MECHANICAL SYSTEMS ENGINEERS, INC.

Per your request, we did a more in-depth code review in response to Mike Nugent's comments regarding fire dampers. As a result of that review we are requesting the following Change Proposal to be issued prior to signing of construction contracts.

GENERAL
MECHANICAL
DETAILS

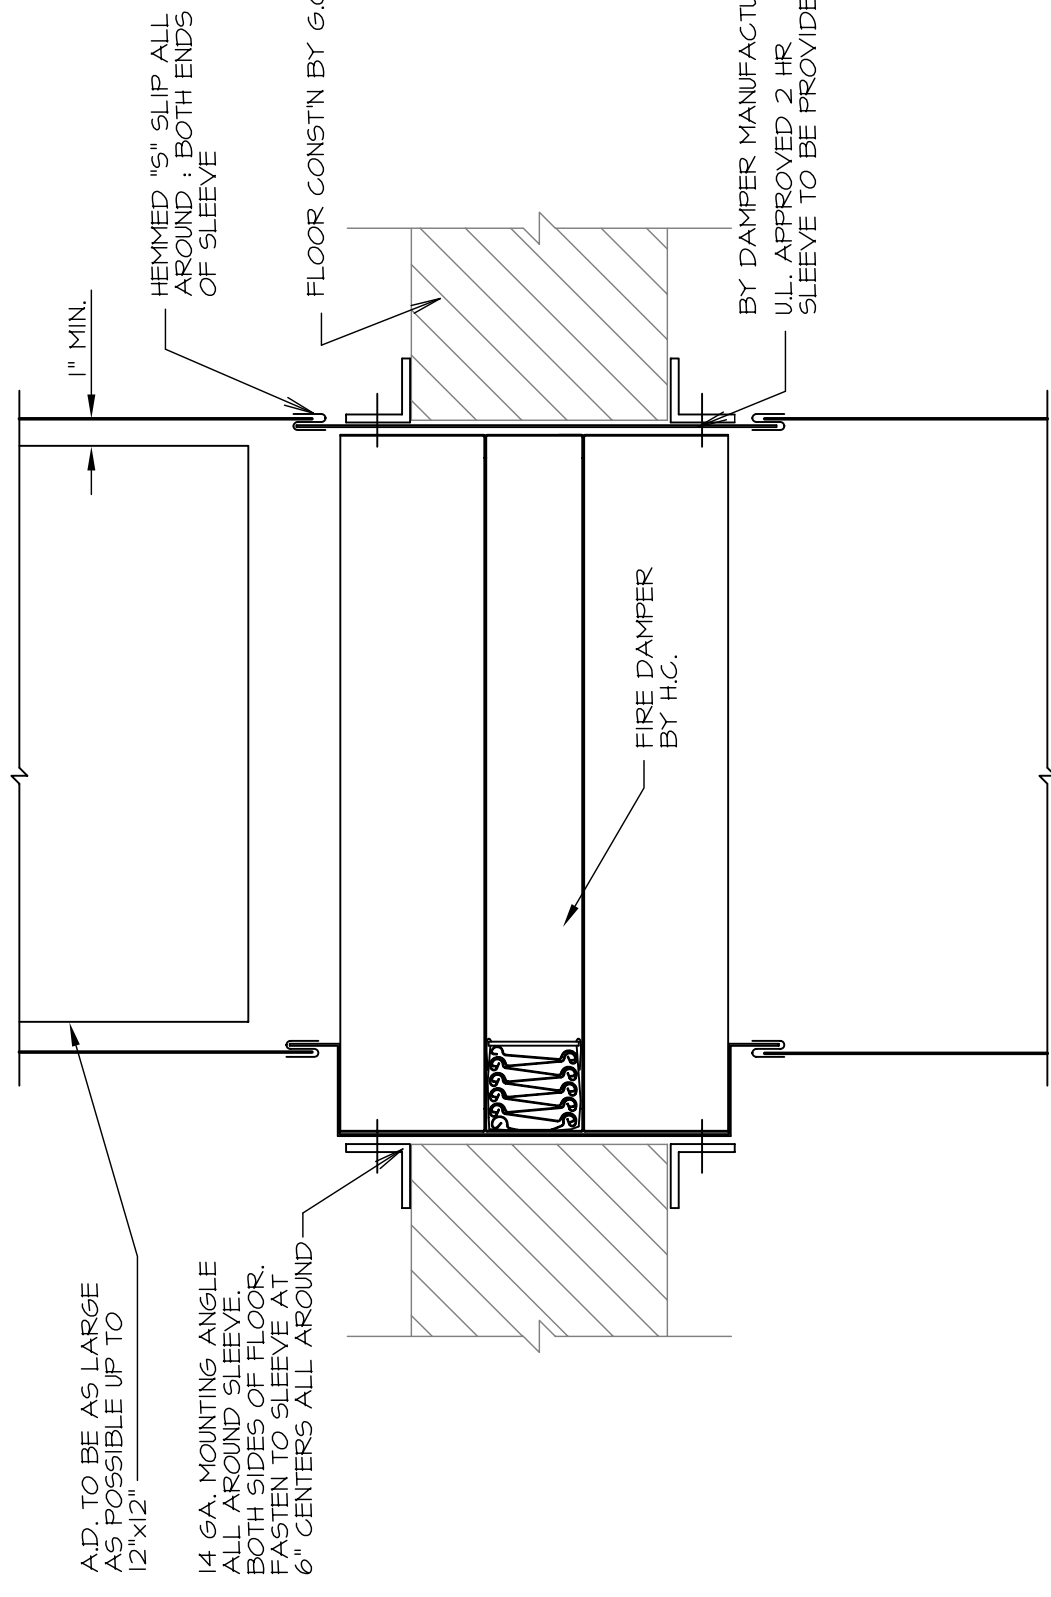
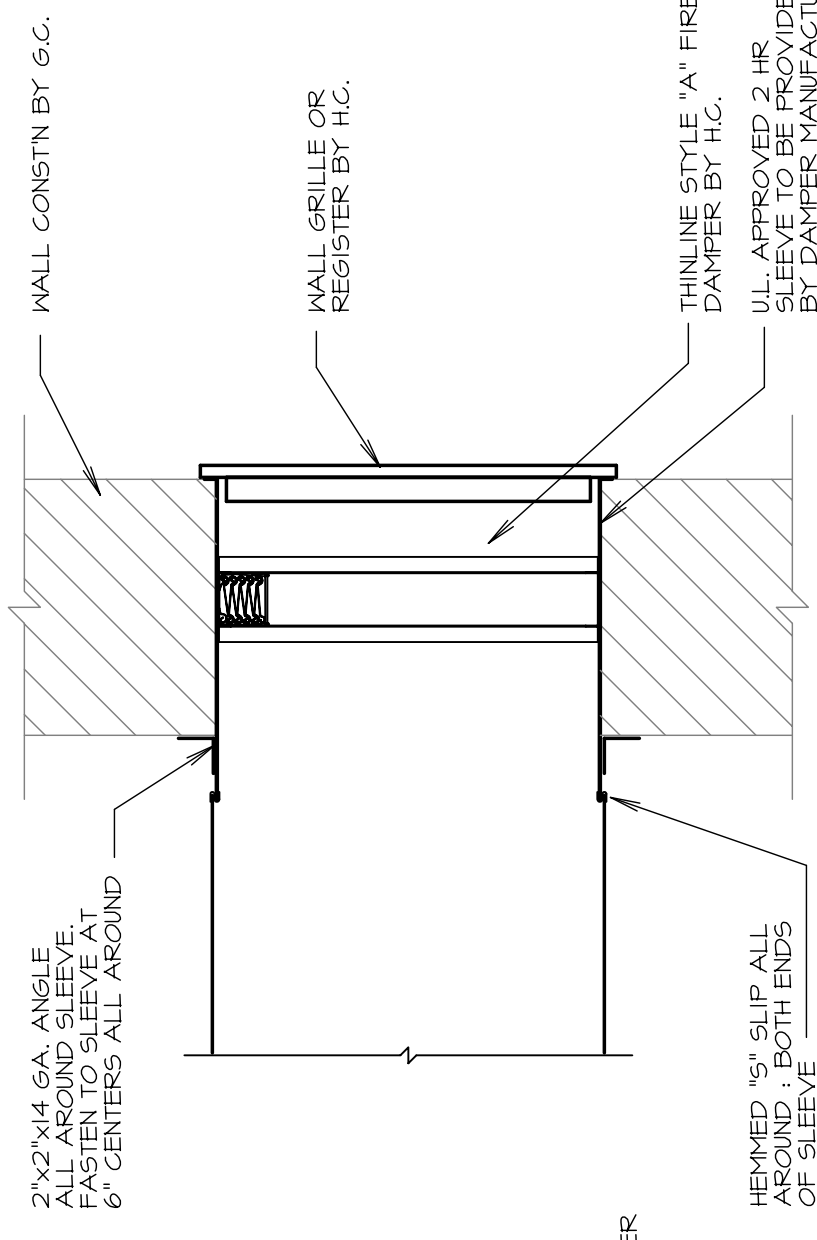
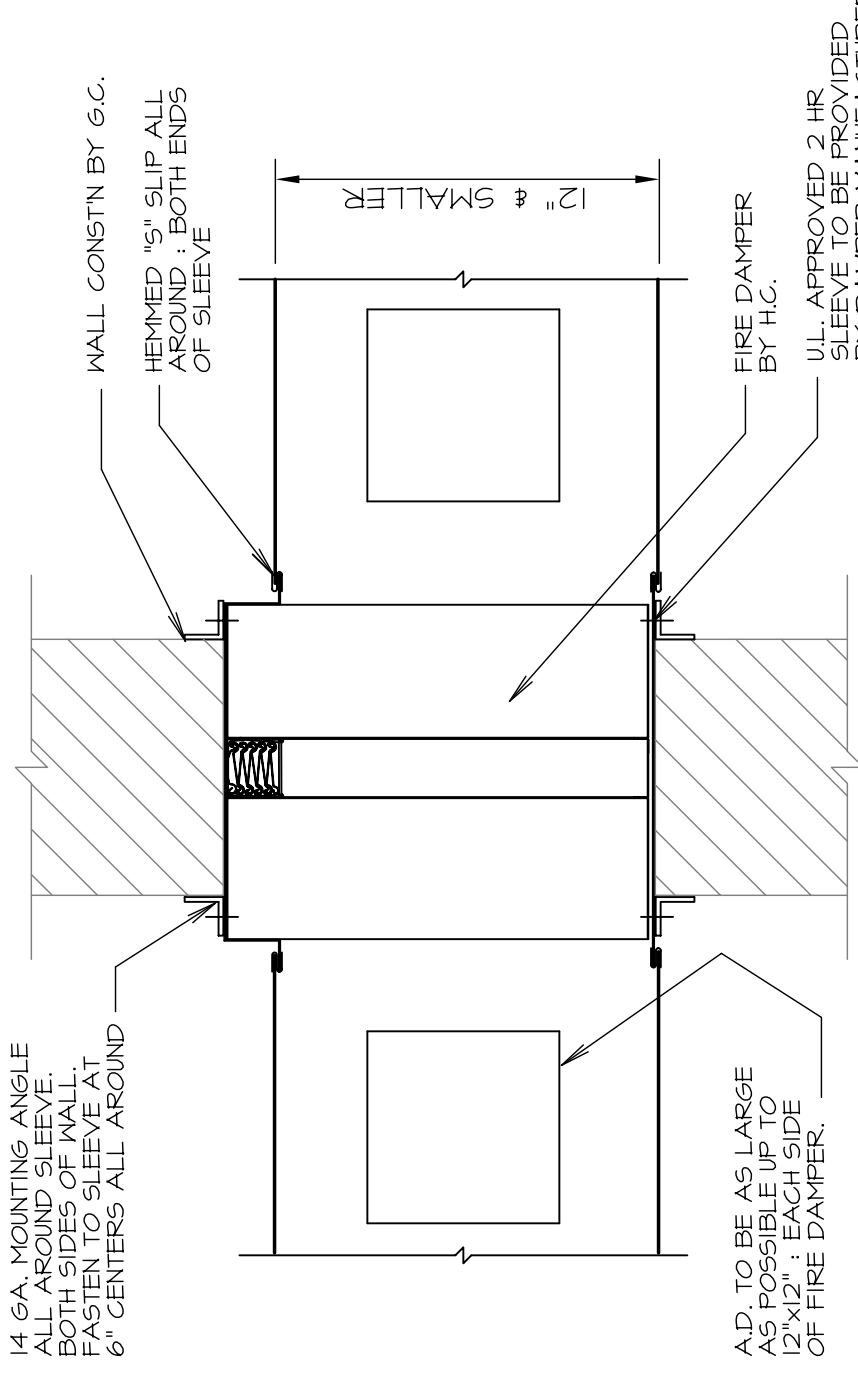
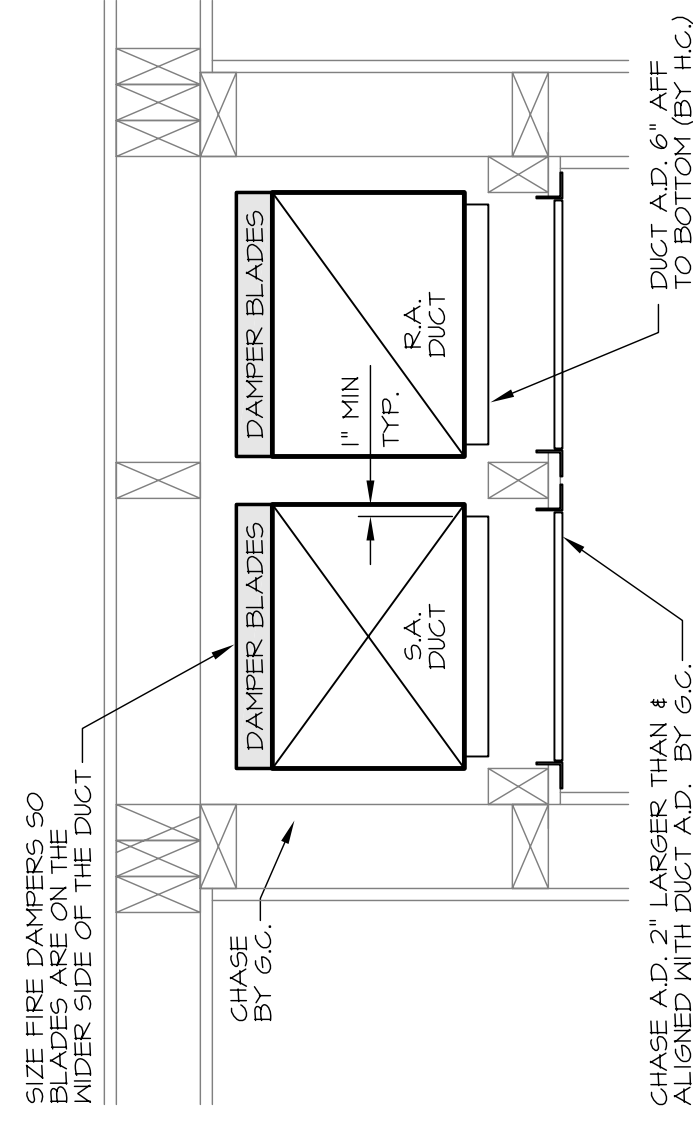
2. All fire dampers for mounting in walls and floors to be provided by damper manufacturer with integral sleeves and mounting angles. Sleeves provided "in-field" are not acceptable. Models indicated are Ruskin to establish a standard: Dampers installed above ceiling registers and grilles shall be designed to mount within ductwork.

- a. Wall and floor types; Model IBDT, Style "B".
 - b. Wall type behind grilles; Model IBDT2, Style "A"
 - c. Above ceiling grilles and registers; Model CFD2W

3. Units (not located behind grilles) shall be style "B" with the curtain isolated out of the stream.
 4. Provide factory mounted fusible links designed to melt at 165°F. and close the damper.

- L. Fire Dampers
 1. Fire dampers shall be installed to comply with NFPA Code No. 90A and shall bear a U.L. label. Provide fire rated access door at each fire damper not accessible through grille. All dampers shall comply with UL555 for dynamic testing and positive closure under air flow.

BUILDING 2
FIRST AND SECOND
FLOOR MECHANICAL
DUCTWORK PLANS

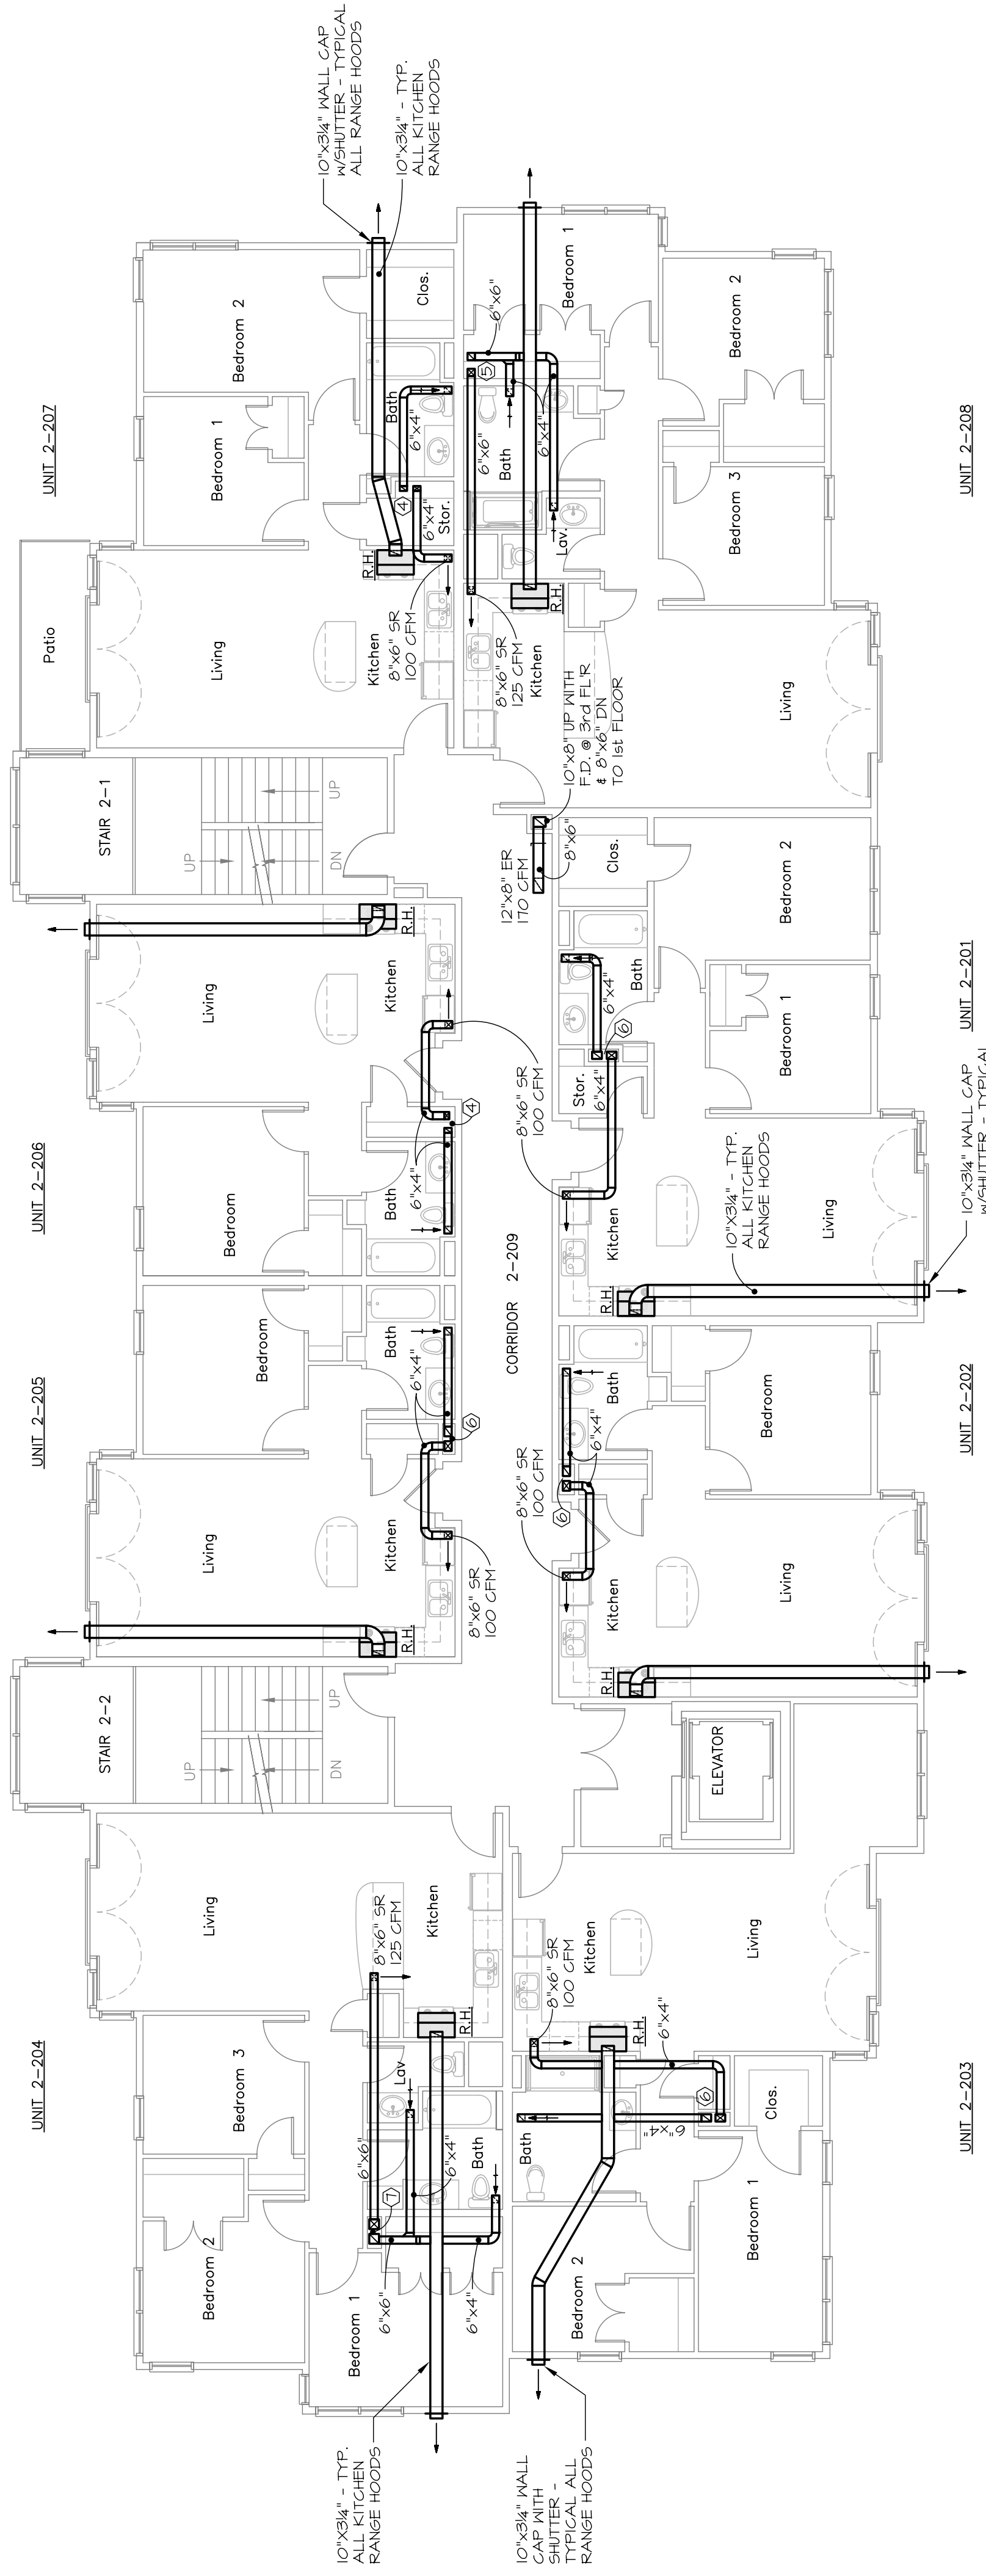
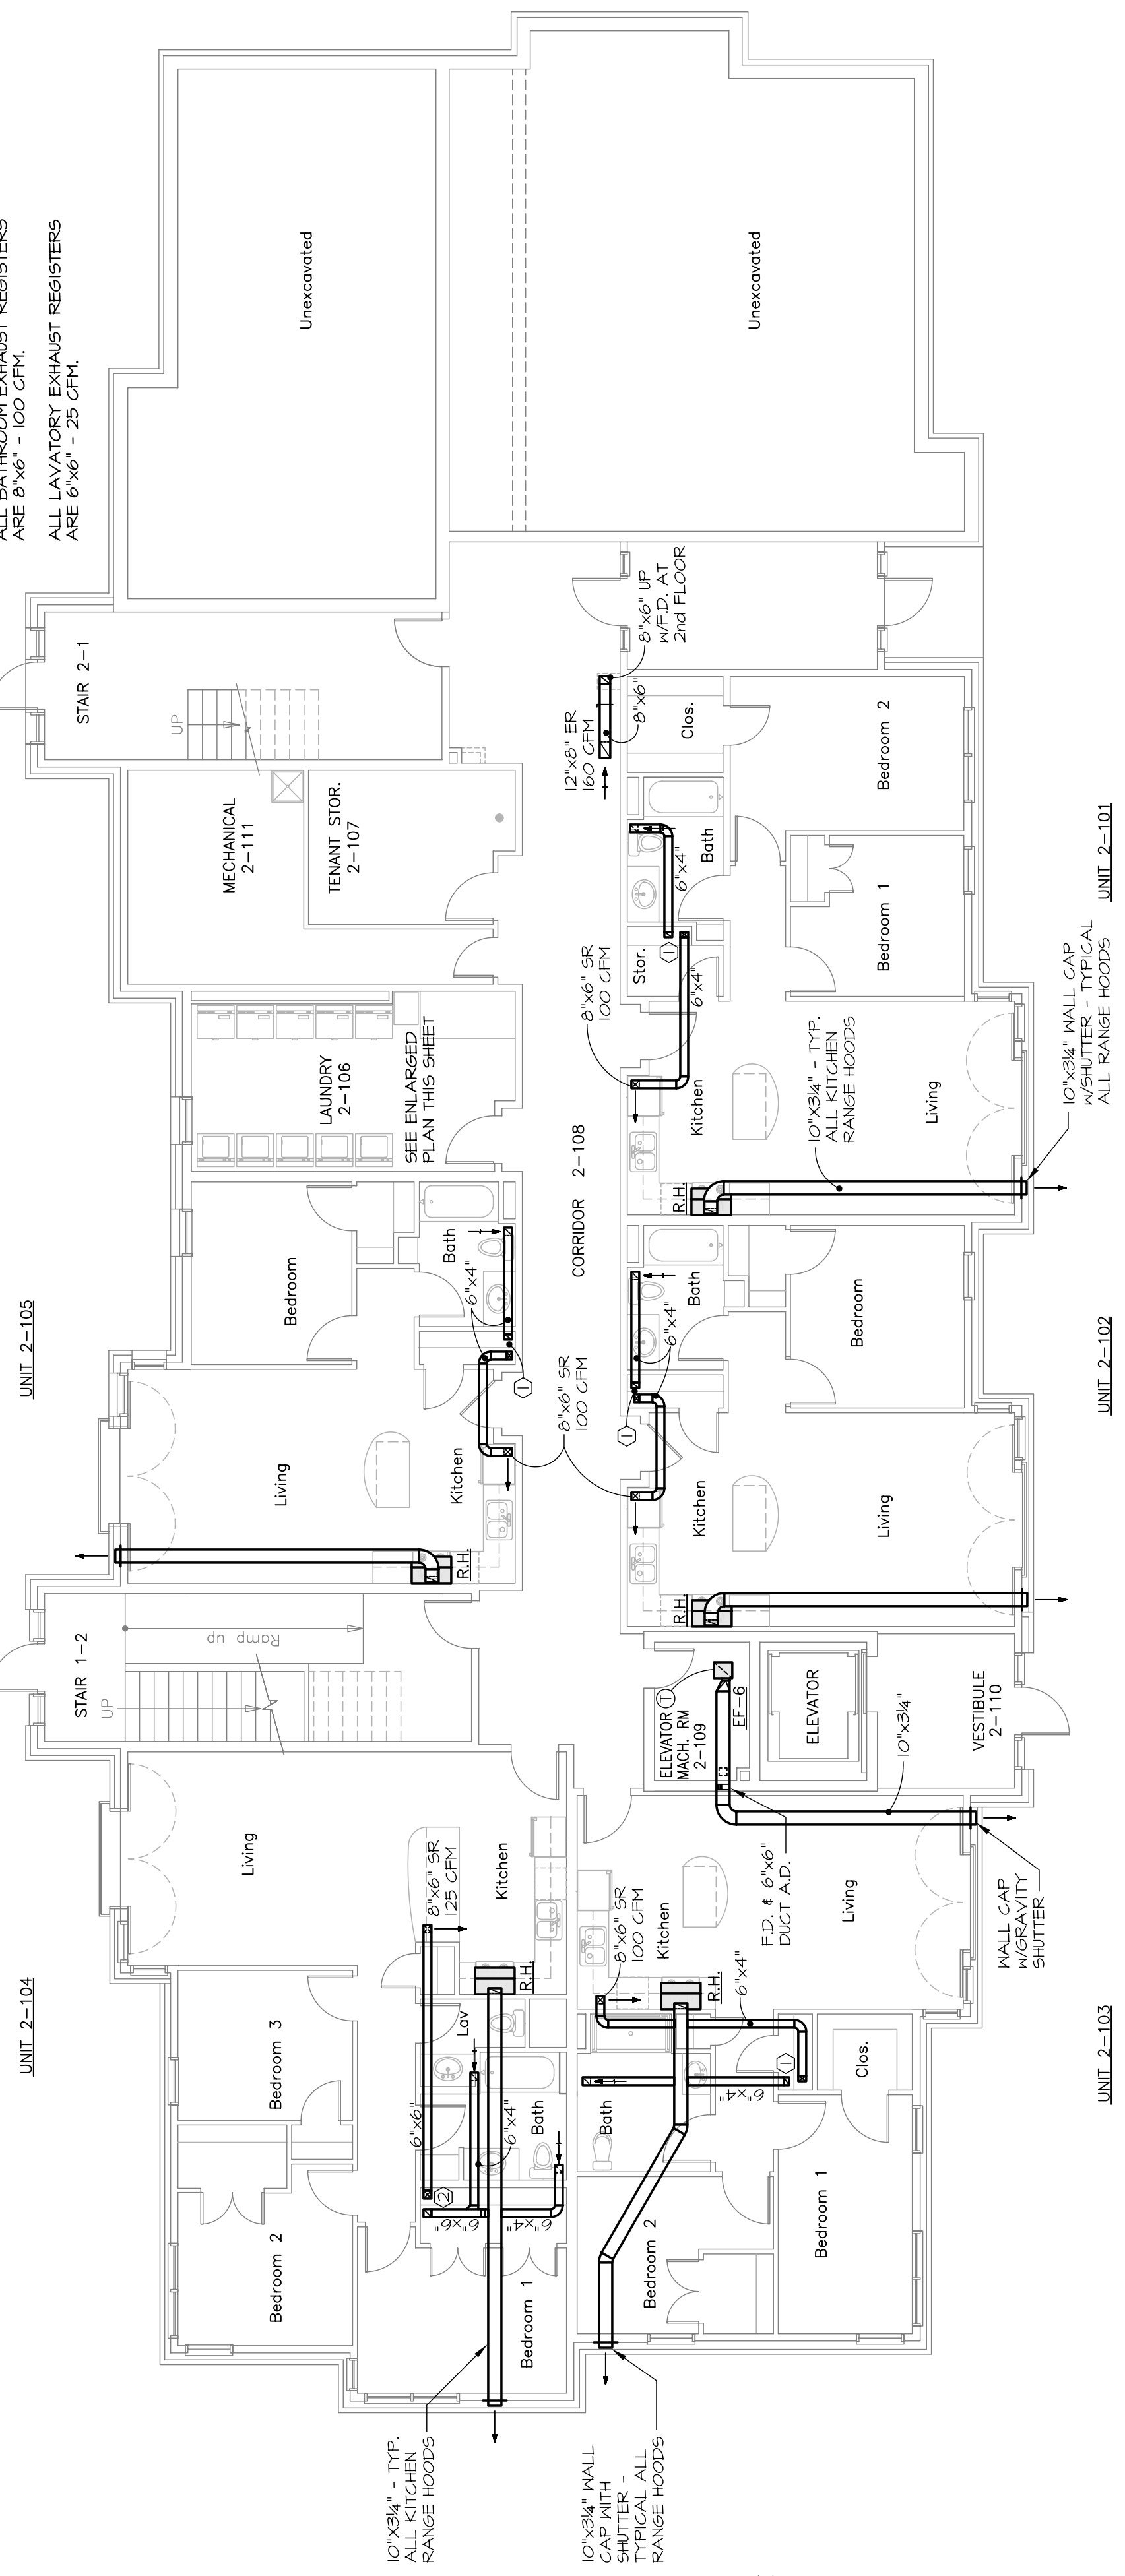
1. Provide a fire damper at all ceiling supply and exhaust registers (and grilles) within apartments and corridors and discharge grille from EF-6 (Building 2). Dampers shall be intended for installation within the ductwork immediately above each register or grille. Please modify specification section 15600, "MECHANICAL", Par. 2.21, "SHEETMETAL", sub-par. "L" to read as follows:
